Re: Railway works and all works necessary to eliminate and, where necessary, upgrade seven numbered level crossings and carry out all associated and ancillary works along a 24-kilometre section of the Dublin to Cork Railway Line.
Fantstown, Thomastown, Ballyhay, Newtown, Ballycoskery (Ballyhea Village), Shinanagh and Buttevant, Co. Cork and Co. Limerick.

RE: Railway Order – Dublin to Cork Railway Line (Eliminate and Upgrade of Level Crossings between Limerick Junction and Mallow) Order 2021 – XC201 Thomastown

We wish to make a submission to An Bord Pleanála in relation to the proposed upgrade and improvement works at Thomastown Kilmallock Railway Crossing by Iarnród Éireann.

Figure 2.5: XC201 Thomastown Proposed Route Alignment

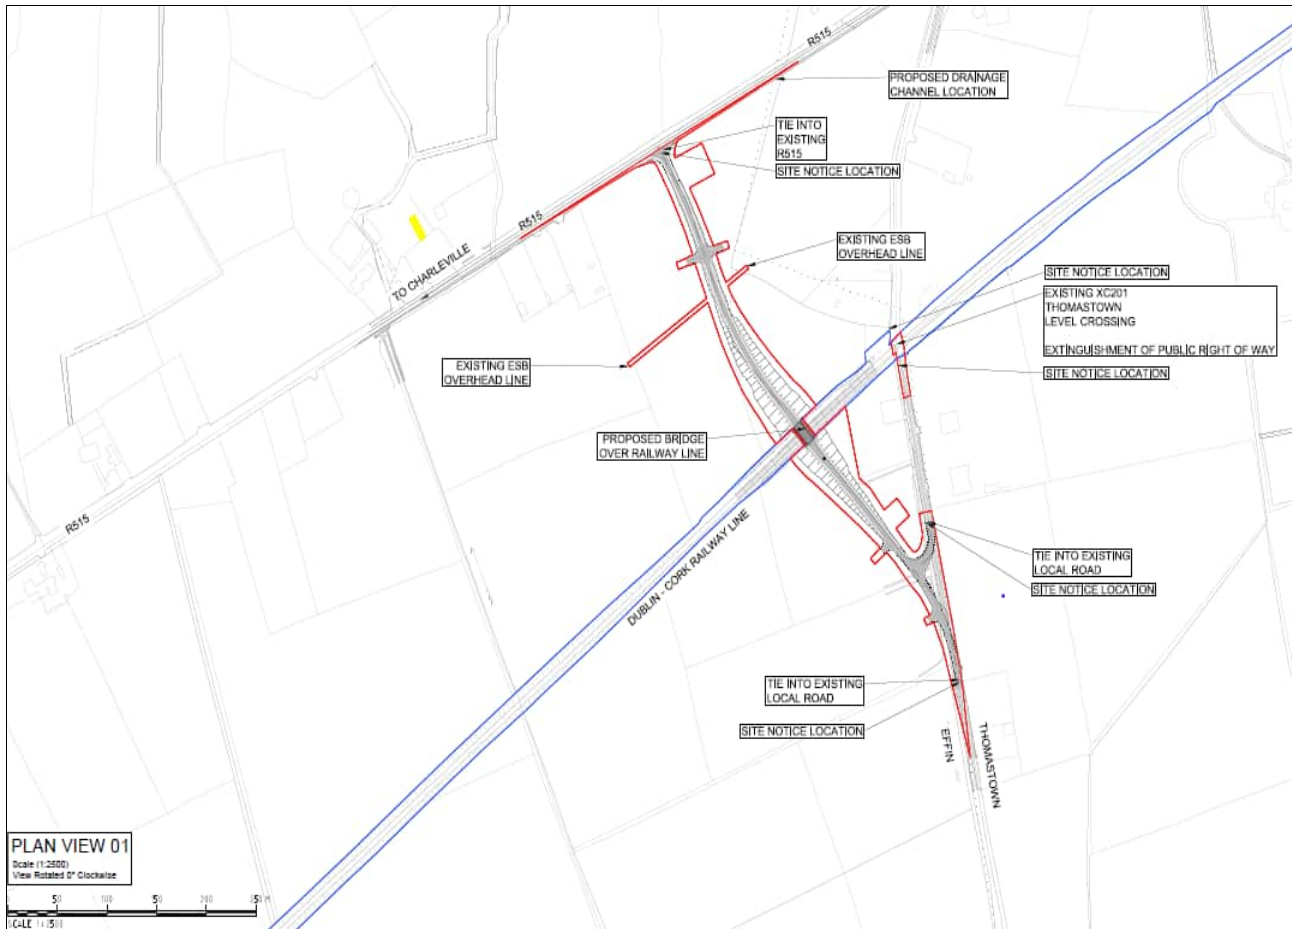
1. As the proposed new bridge will provide a birds eye view into my farmyard and Brother Donie Cotter's house we would like to see some screening put in place which would afford us some privacy for security purposes.

3. The current proposal for exiting R515 onto the new road is wholly unacceptable as it has the potential to be highly dangerous due to the high volume of traffic on the main Charleville Kilmallock road R515. We feel a filter lane from R515 onto the new road is necessary to exit off the R515 in a safe manner.

4. As the road will link a currently divided parish it is inevitable that traffic will increase substantially and in the interest of the safety of all road users (i.e. cars, farm machinery and trucks) it is essentially that the new proposed road is a two lane roadway, allowing two vehicles to safely pass in order for it to be fit for purpose and carry the volume of traffic that will be created by linking the parish. Realistically anything less than a two lane roadway is a step backwards.

5. Currently all heavy goods vehicles access my farmyard using the level crossing. As this is an essential part of my business it further reiterates the need for an improvement to the current proposal for the road.

Drawing file: XC201 Thomastown / Plan 2A Thomastown Landowner Property Plan.pdf

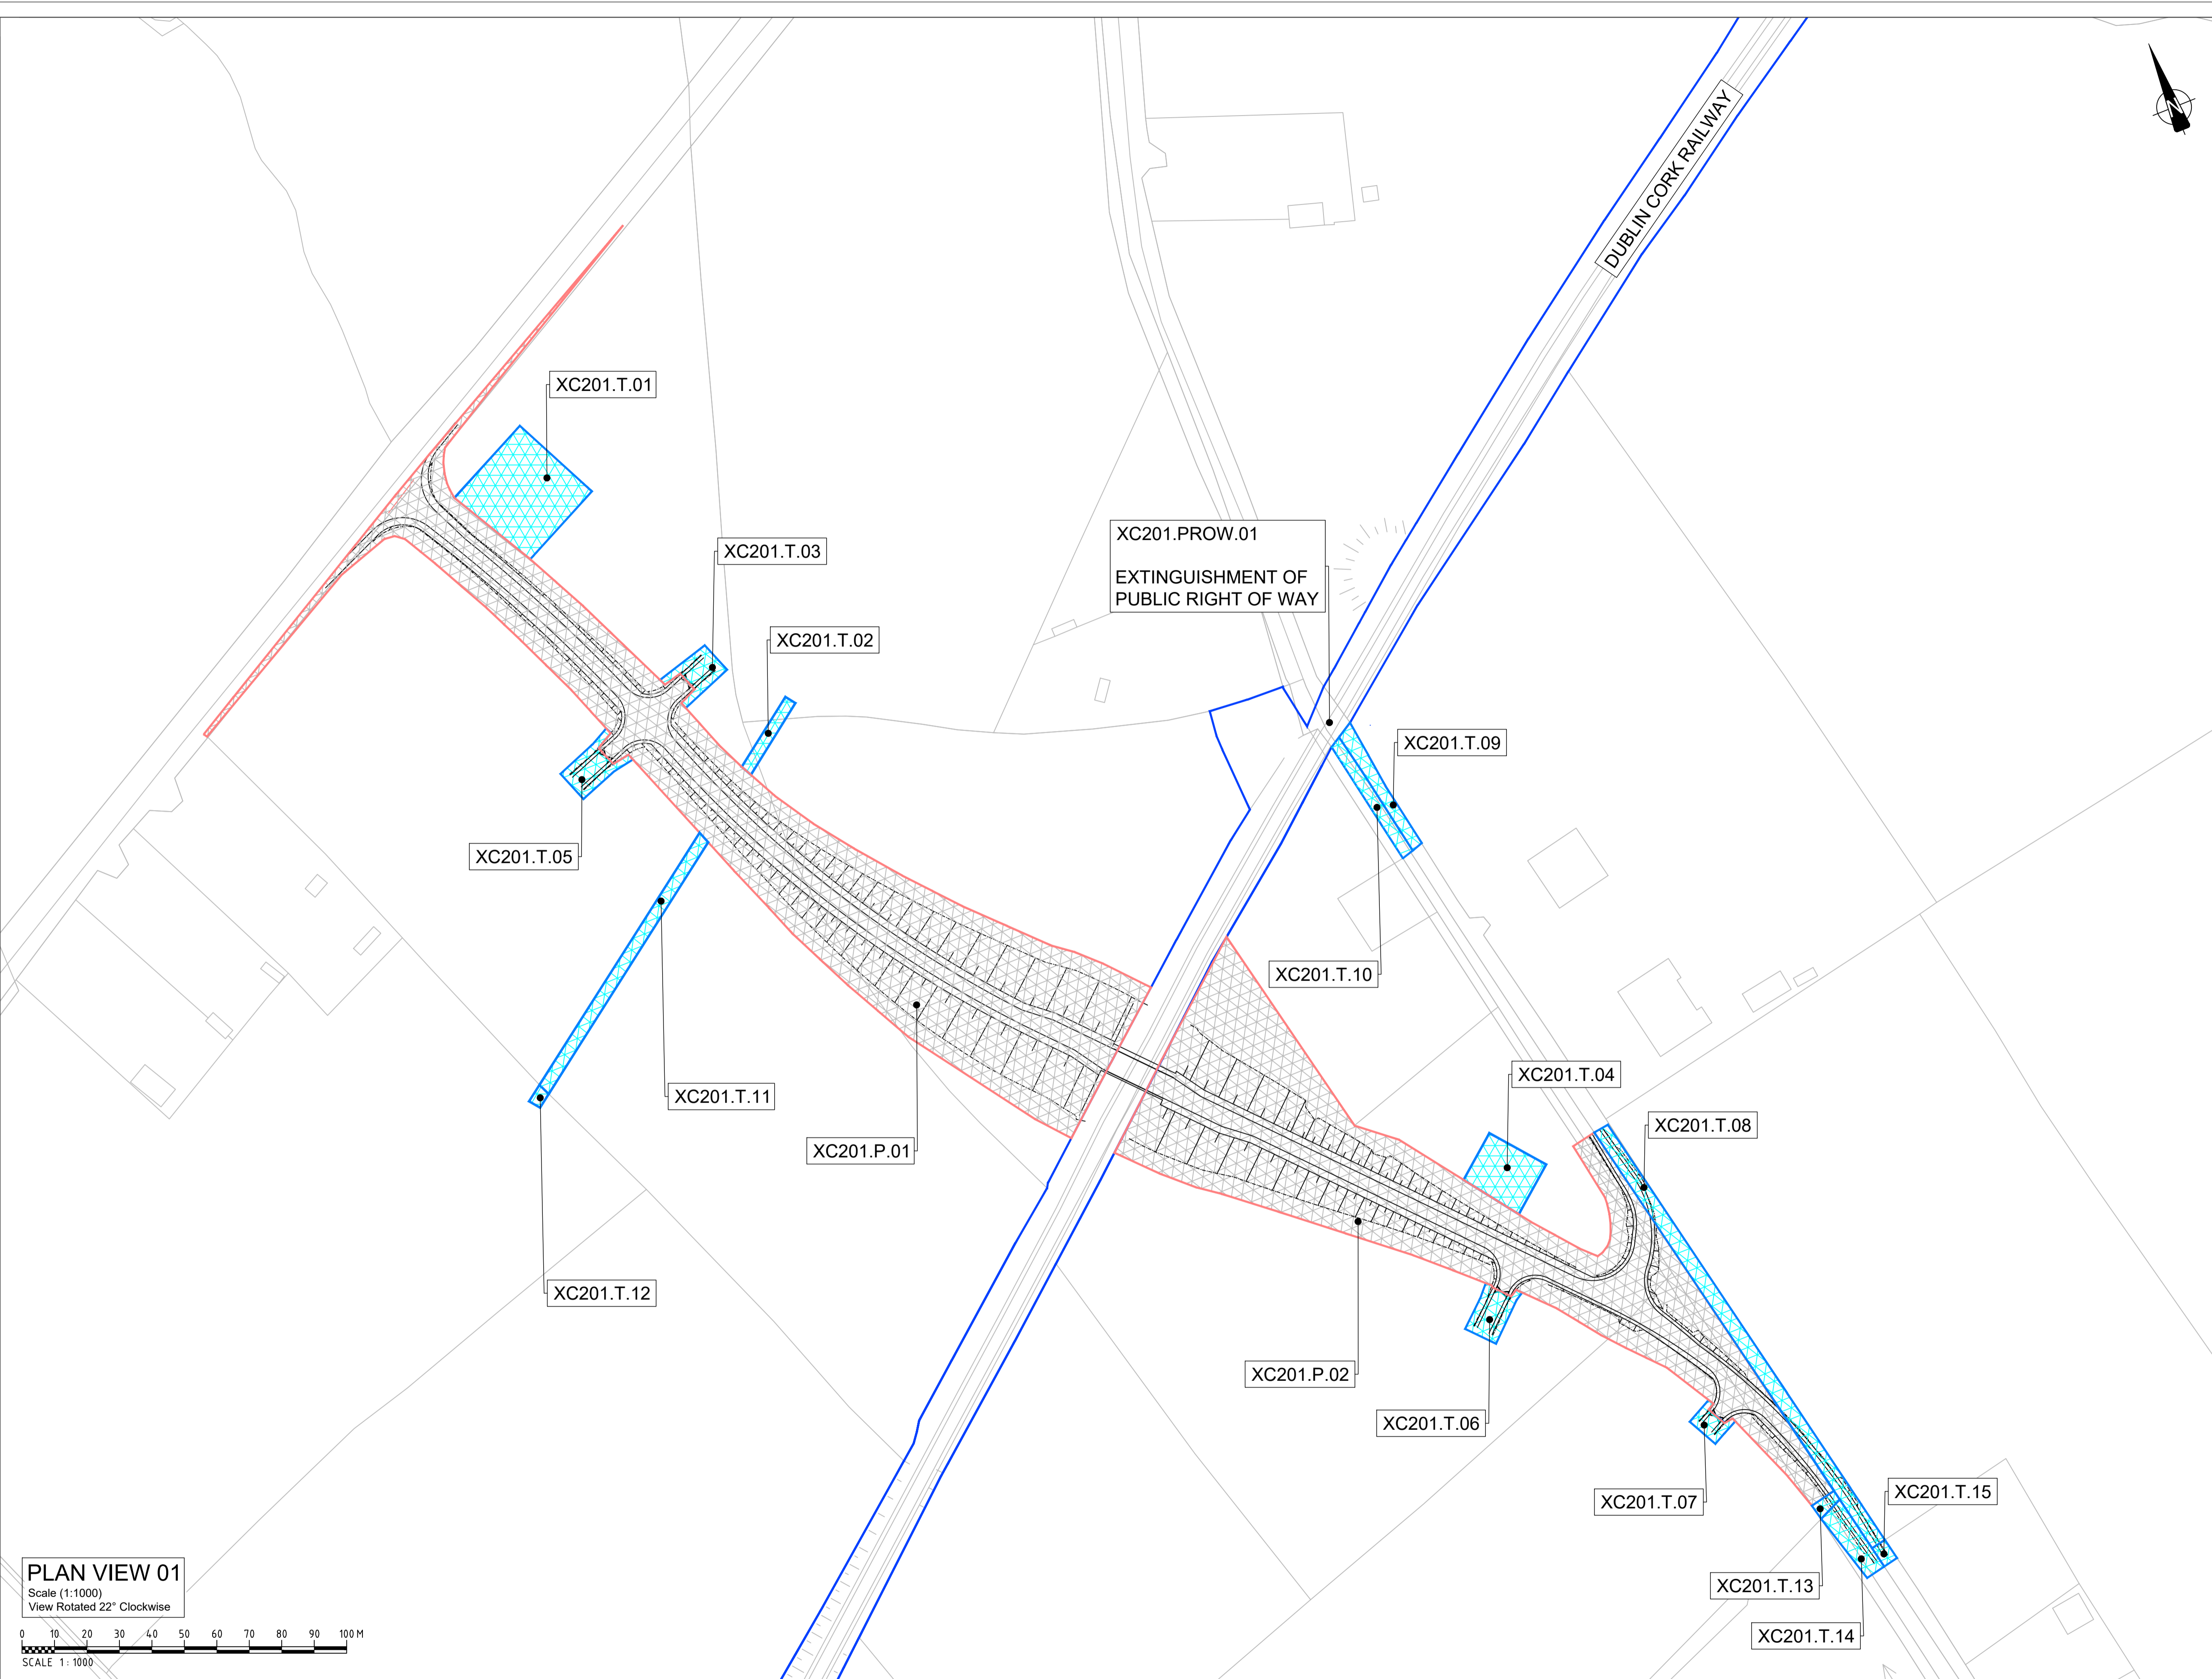
2. The areas marked XC201.T.09, XC201.T.10, XC201.T.08 and island of land adjacent to XC201.T.08 on the proposed Plan 2A appear to be "no man's land" and ownership of these areas needs to be established in order to avoid those becoming areas for illegal dumping or anti-social activities.
